Consultation Response: Kirklees Council Environment Unit

2012/92106 Denby Lane, Upper Denby

Plans, Elevations & Site Plan
As Proposed

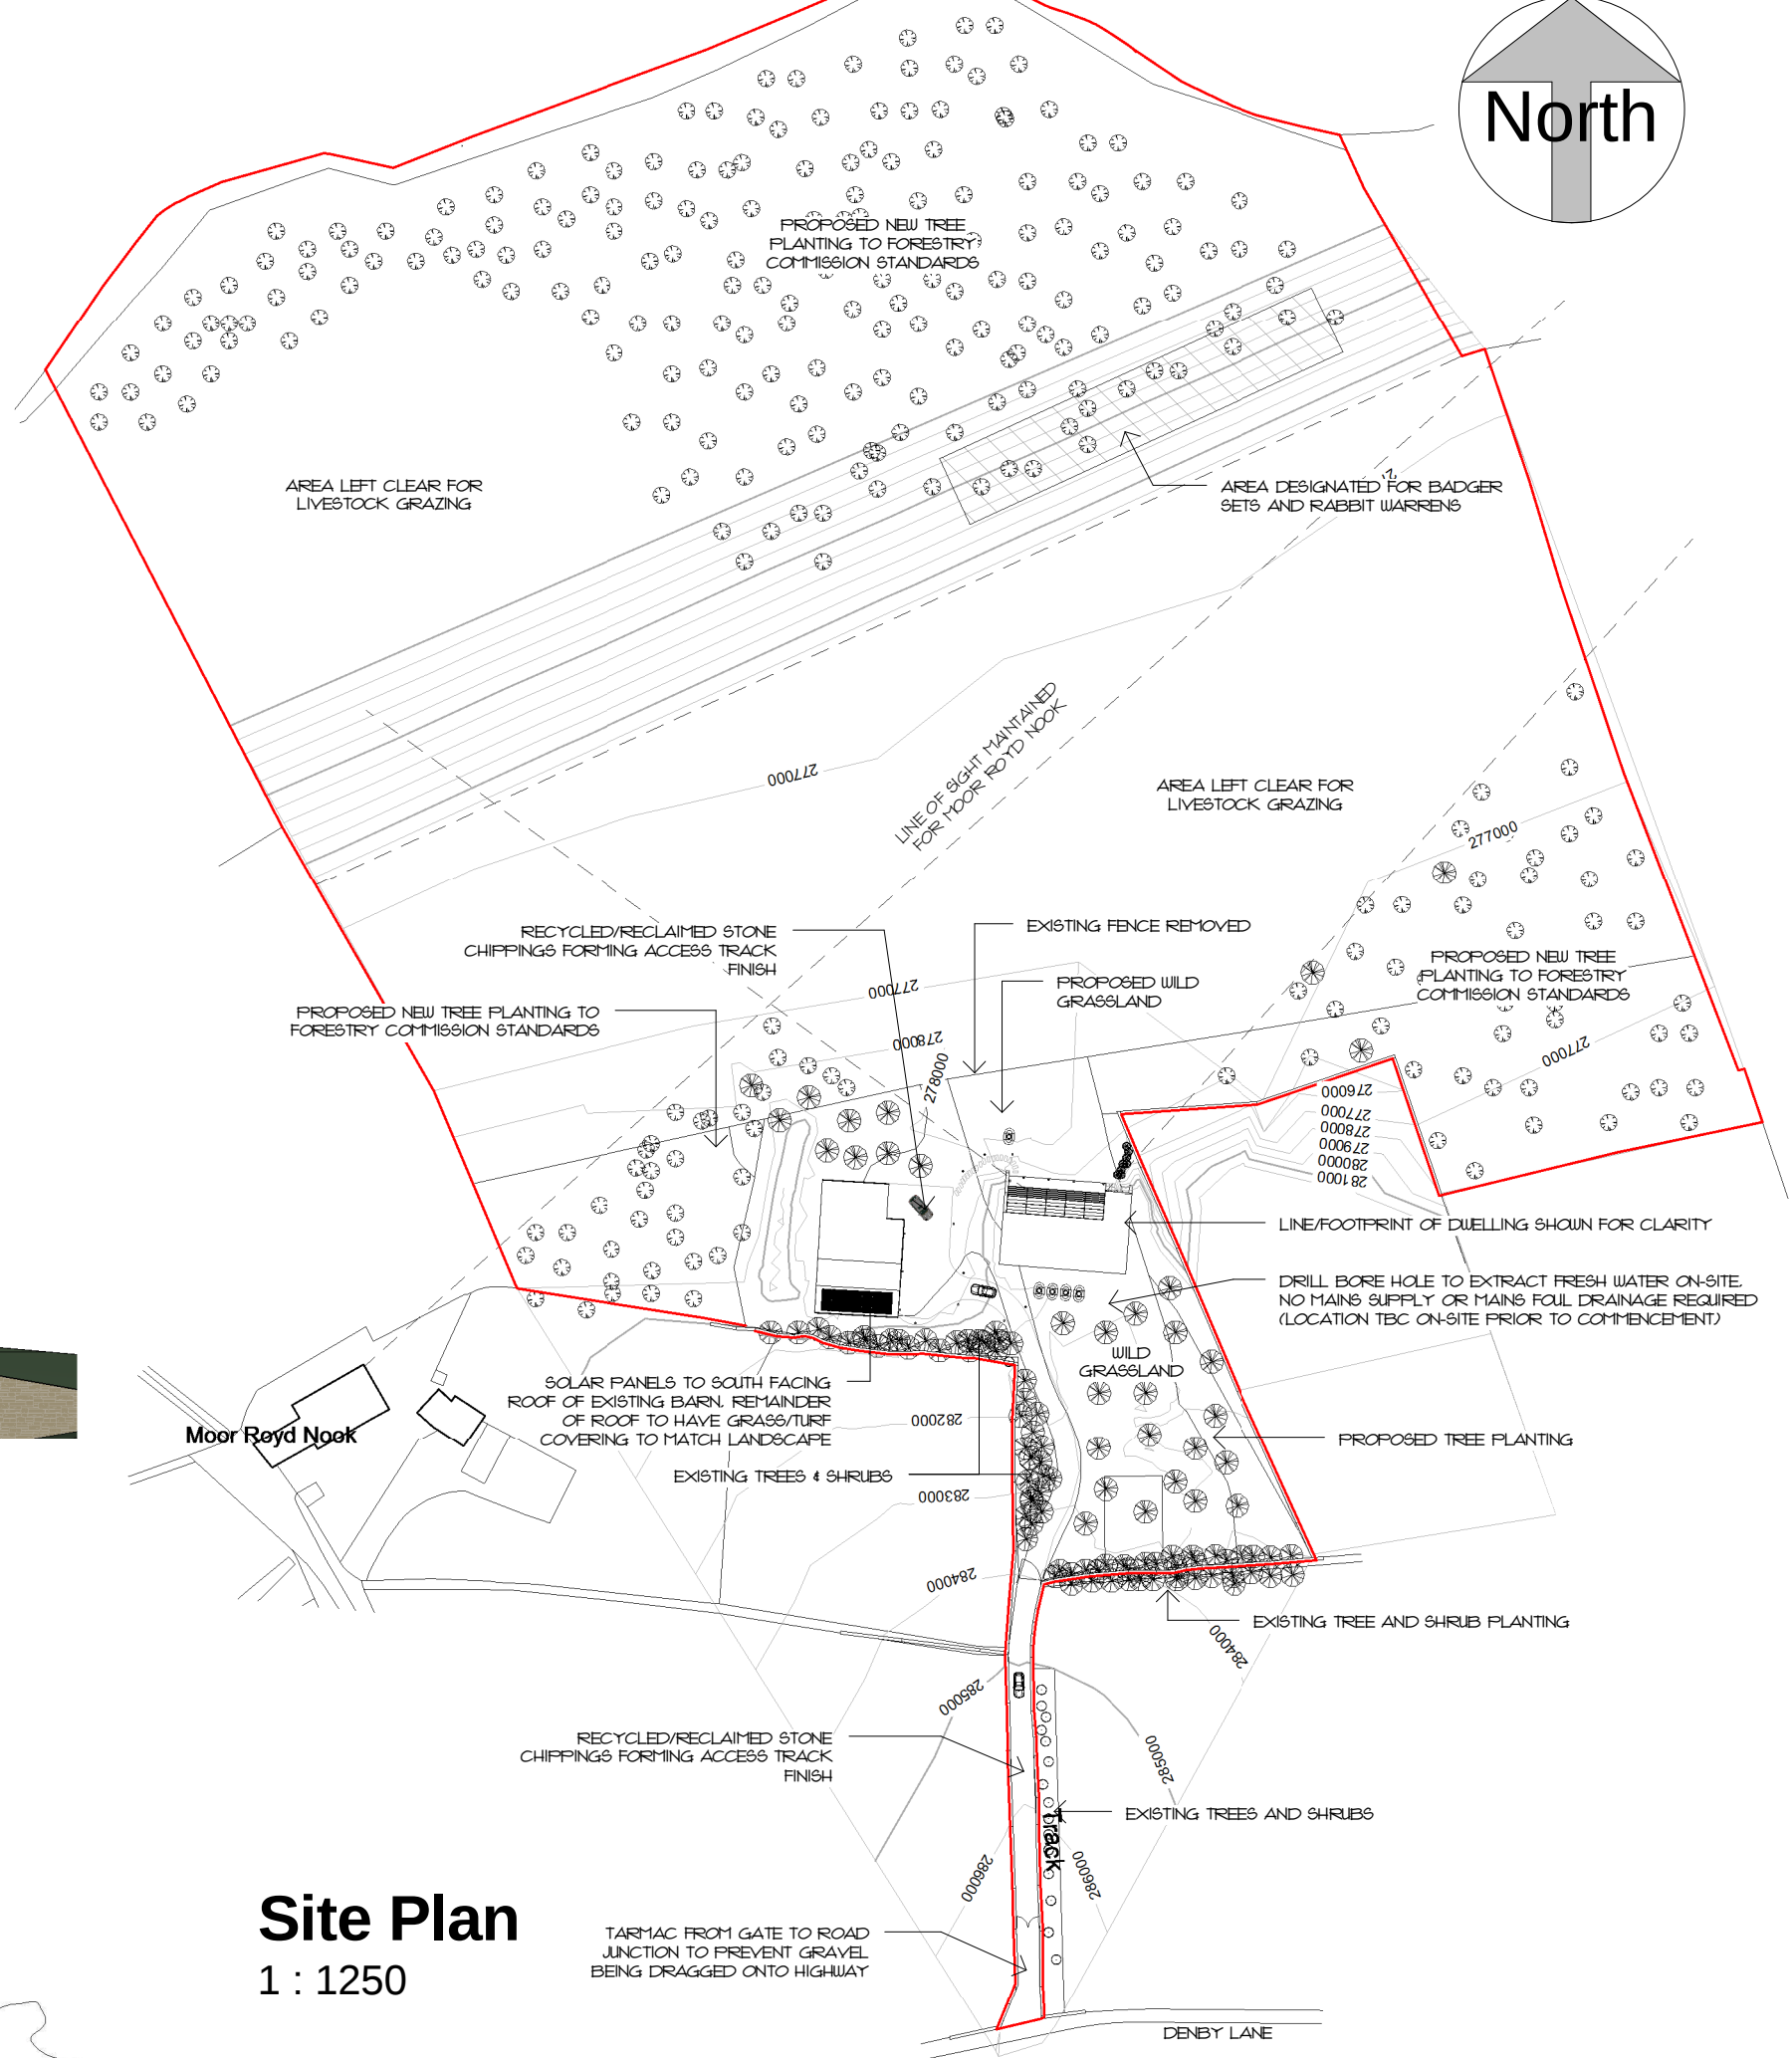
The plans propose a considerable amount of woodland creation on areas that currently are grazed. Whilst we are supportive of woodland planting in principle, for this site the woodland should be carefully designed to not be detrimental to (and preferably enhance) the more open habitats of Denby Delf SSI (in line with policy NE3) and woodland to the north. At present, it is only stated that the new woodland will be planted to 'Forestry Commission standard'. This is insufficient for the purposes of determining the application.

Further detail is required, including:

- A Phase 1 habitat assessment of the habitats currently present on site (ie the value of the grassland)
- The type of woodland proposed. As this is being presented as a biodiversity enhancement, the woodland should be made up of a diverse range of native species that are appropriate to the area. This should be detailed.
- Density of woodland planting should be adjusted to provide lower density woodland/woodland edge/wood pasture for the area adjoining Denby Delf. The proposals should complement and enhance the habitats currently present at Denby Delf.
- The woodland should be designed to be naturalistic, avoiding straight and abrupt edges.
- An area is identified on the plan as designated for Badger Setts and 'Rabbit Warrens'. We would not recommend deliberately creating rabbit warrens given the problems this species can cause.
